AGENDA ITEM: DFT Project Number: PR-2023-008423

Application Number: SI-2023-00606 Project Name: 4821 Pan American West – Lexus

PARKS AND RECREATION DEPARTMENT COMMENTS & APPLICANT RESPONSES

HEARING DATE: 4/5/23

**PLANTING LEGEND & SCHEDULE**

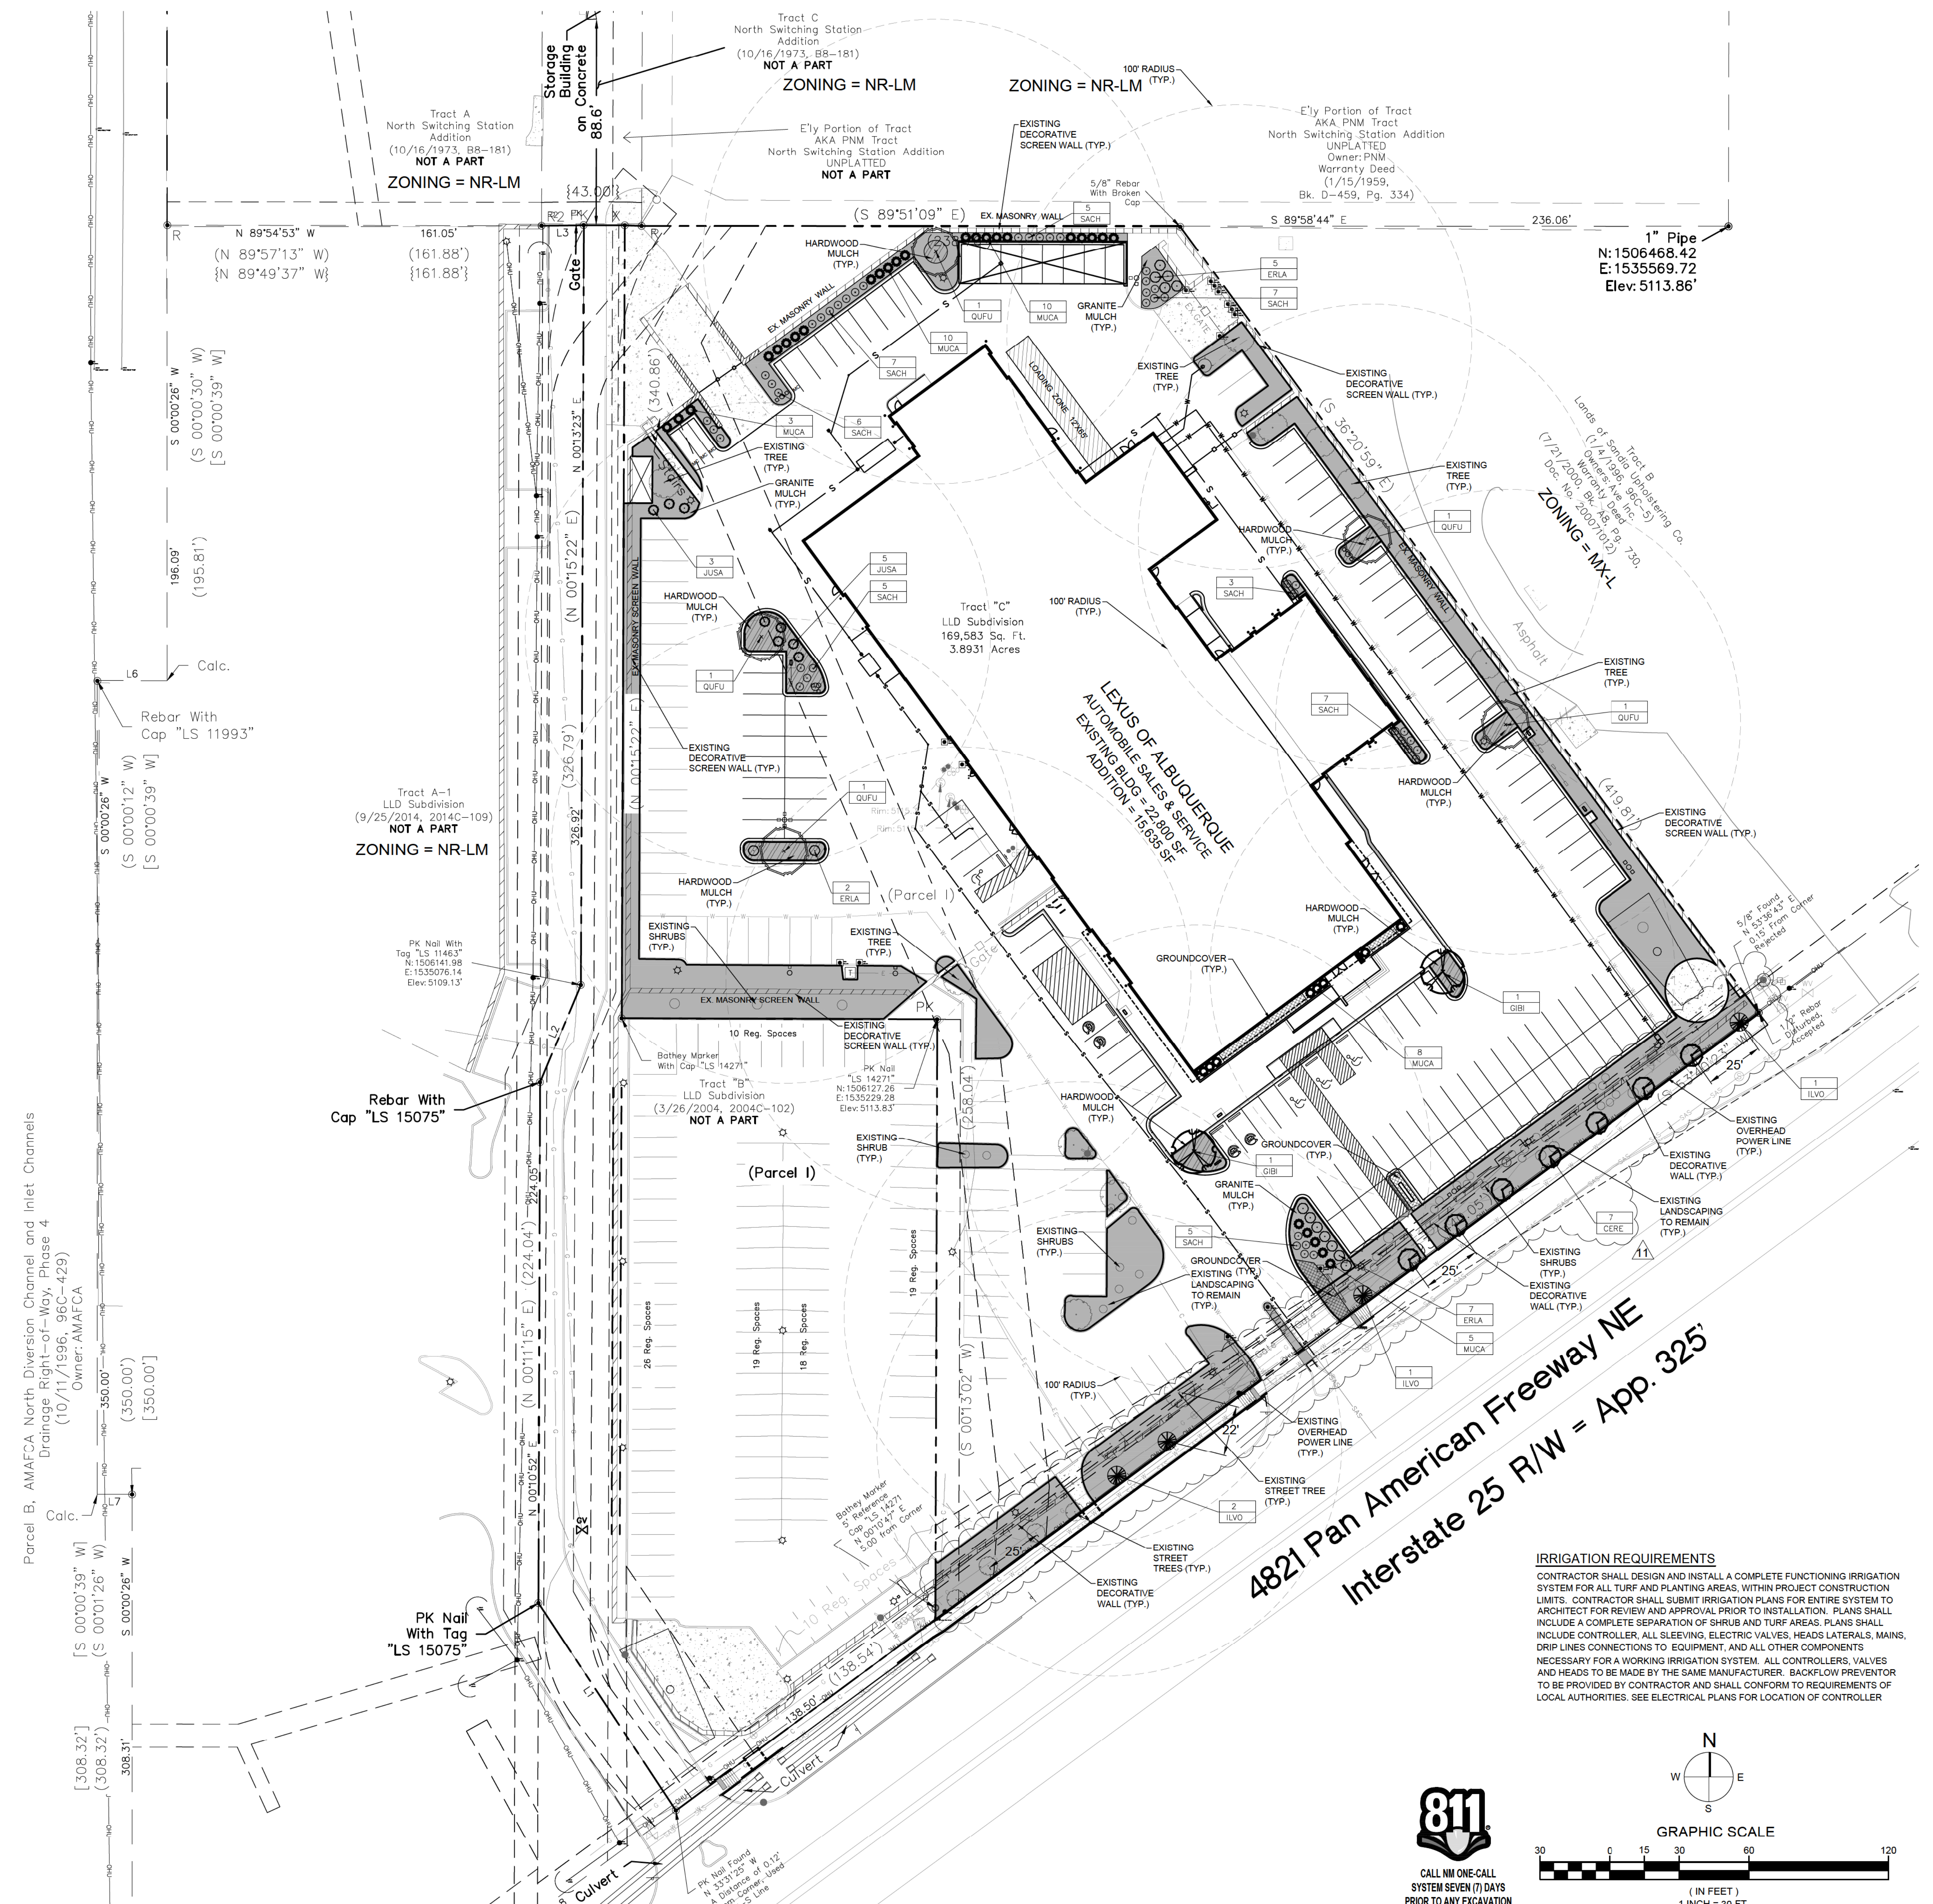
1. Street Trees are required every 25' on center. Please clarify whether existing trees meet this requirement on the landscape plan.

RESPONSE: We've revised the landscape plan with dimensions and slightly adjusted the layout of proposed trees to ensure we meet the 25' required spacing.
